Application No: EP/11/22/HH
Site Address: 24 Normandy Lane East Preston BN16 1LY
Description of works: Erection of single storey rear extension and external alterations following the demolition of existing rear conservatory/lean to.

OWQC44882

The Planning & Licensing Committee of this council considered this Application at its meeting on Monday, 28th February.

MR & MRS McGONIGLE	24 NORMANDY LANE EAST PRESTON WEST SUSSEX BN16 1LY	PROPOSED FRONT ELEVATION	P.D. ELKINS DRAWING SERVICES LIMITED 140 Kingston Road Ewell Surrey KT17 2ES Tel. 020 8873 3138 email. elkinsdraw@aol.com
--------------------	--	-----------------------------	--

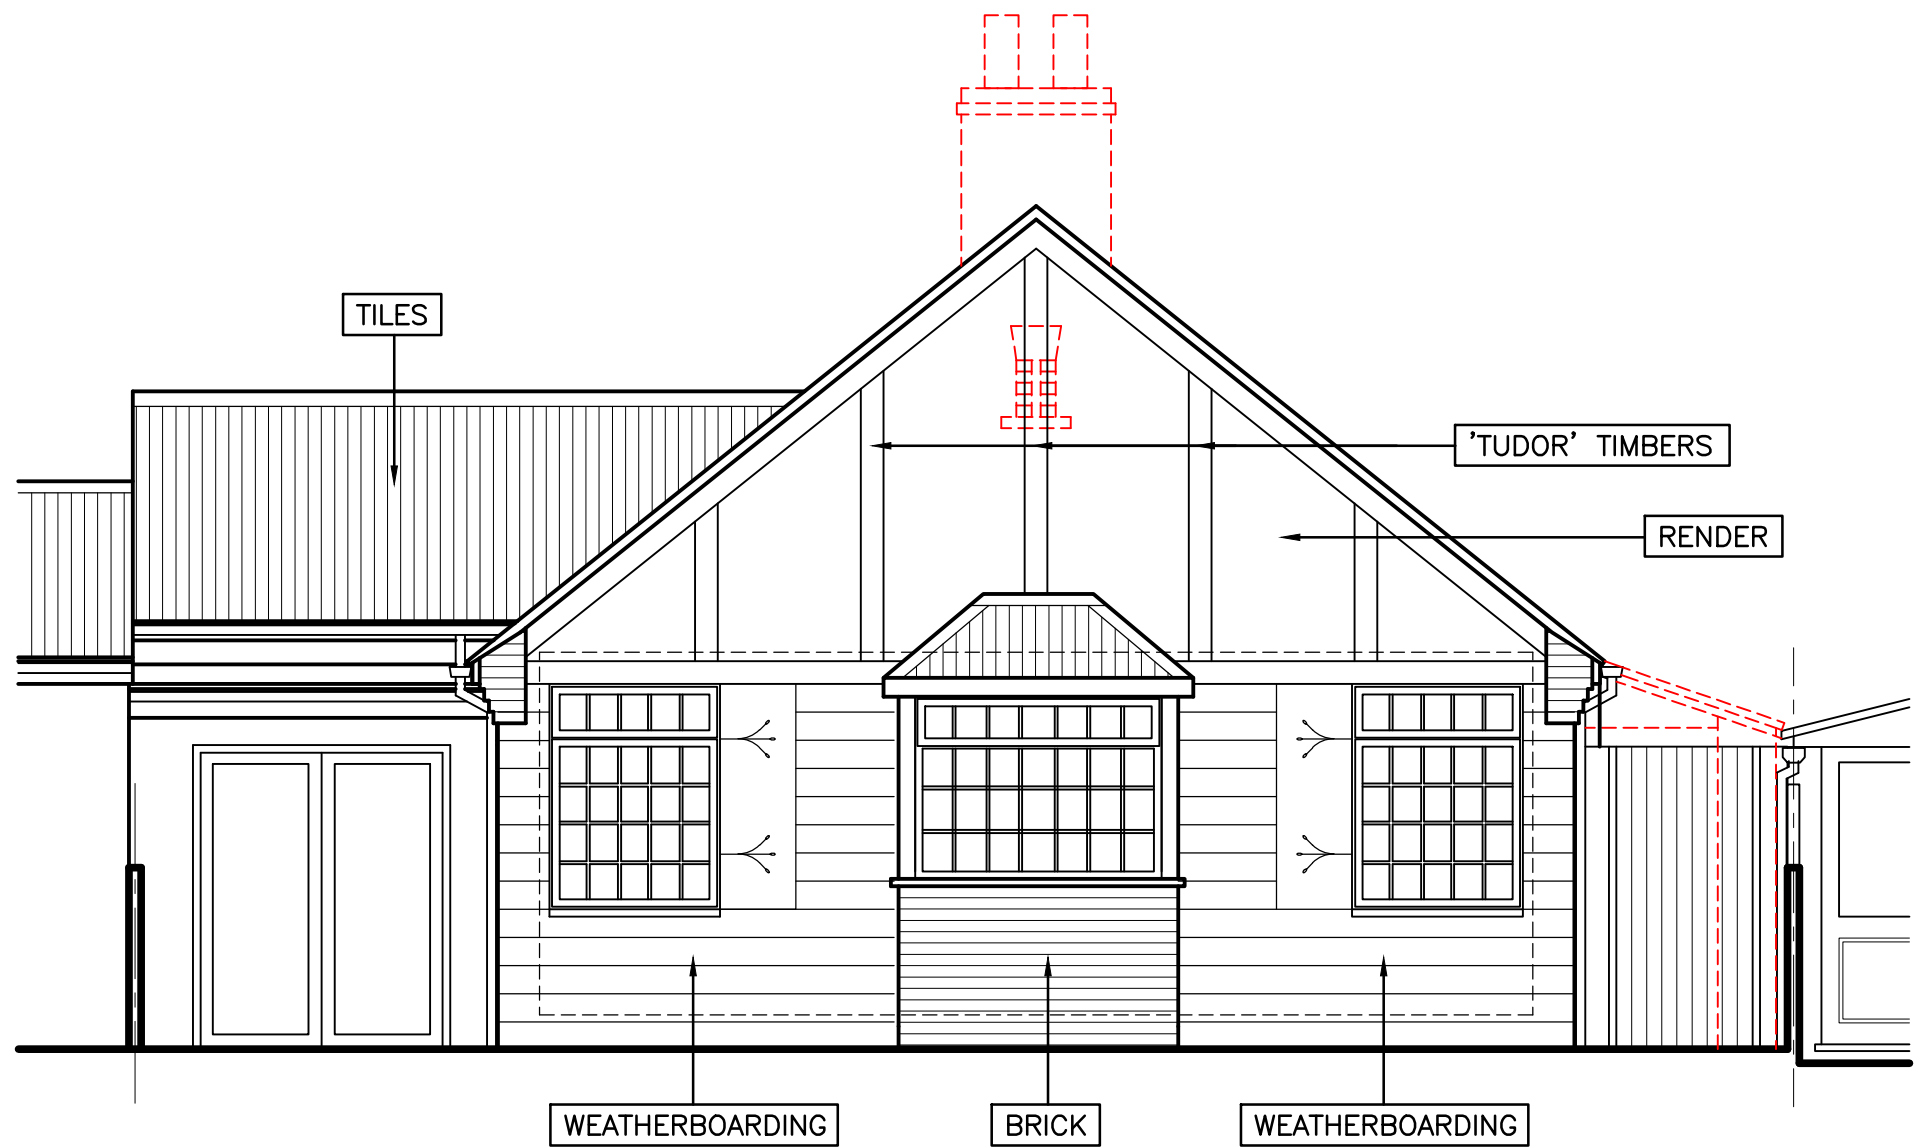
The committee also agreed it would object to this Application as the proposed Tudor detailing will be completely out of character with the rest of the road. The loss of the original brick frontage design would be very regrettable.

MR & MRS McGONIGLE	24 NORMANDY LANE EAST PRESTON WEST SUSSEX BN16 1LY	PROPOSED SIDE ELEVATION 'B'	P.D. ELKINS DRAWING SERVICES LIMITED 140 Kingston Road Ewell Surrey KT17 2ES Tel. 020 8873 3138 email. elkinsdraw@aol.com
--------------------	--	--------------------------------	--

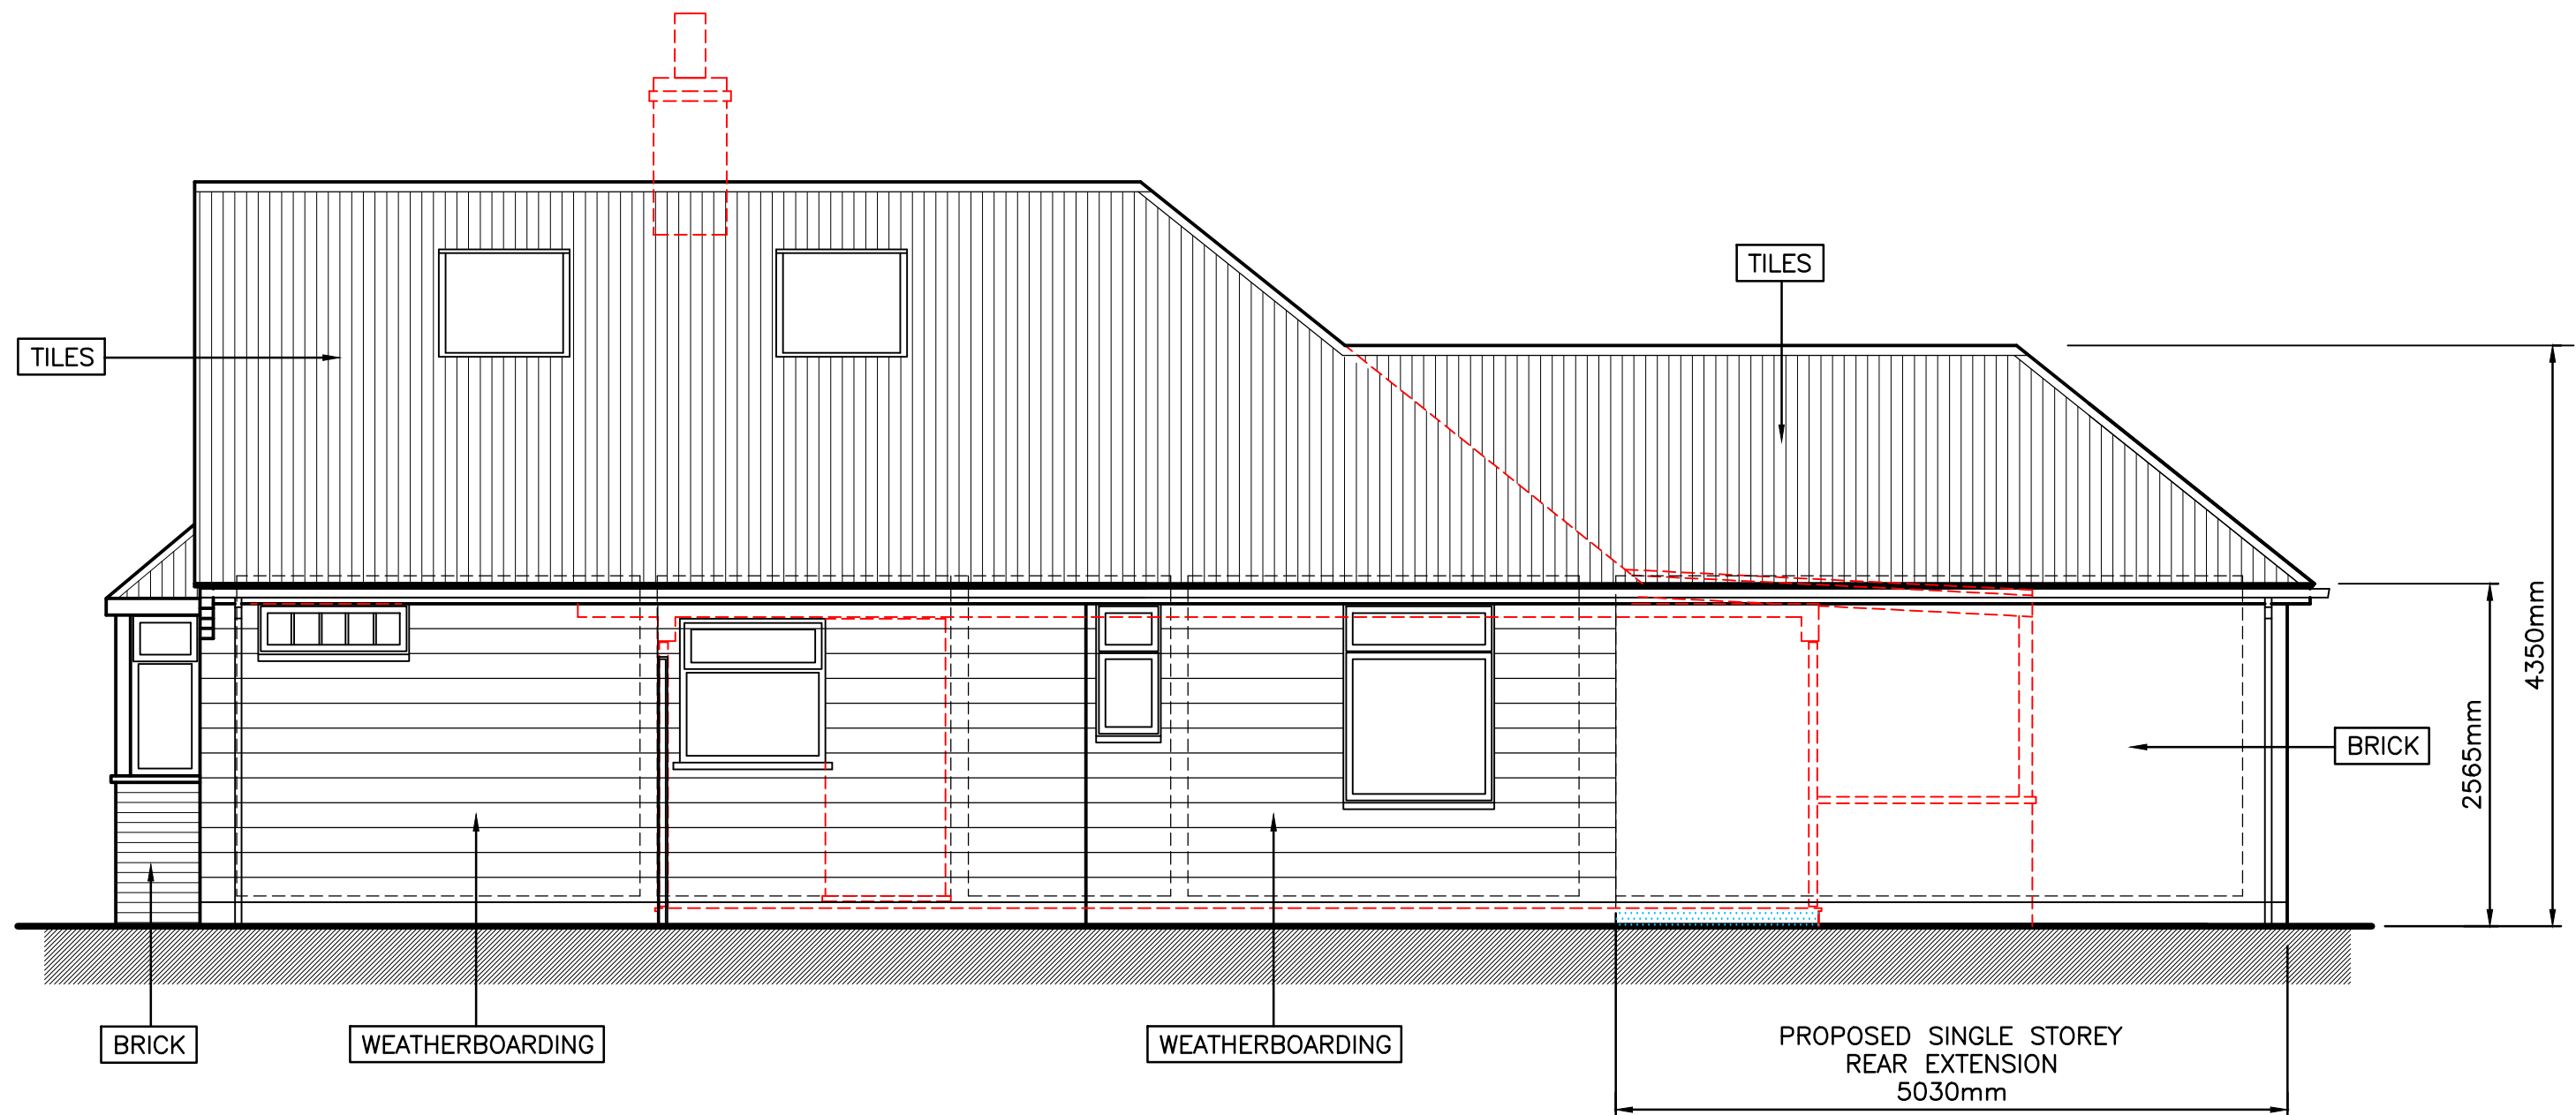
The committee was concerned about the visibility of the proposed extension will be to people walking past the property. To some extent, this will further erode the spatial character of the road, contrary to Policy D DM1 of the Arun Local Plan.
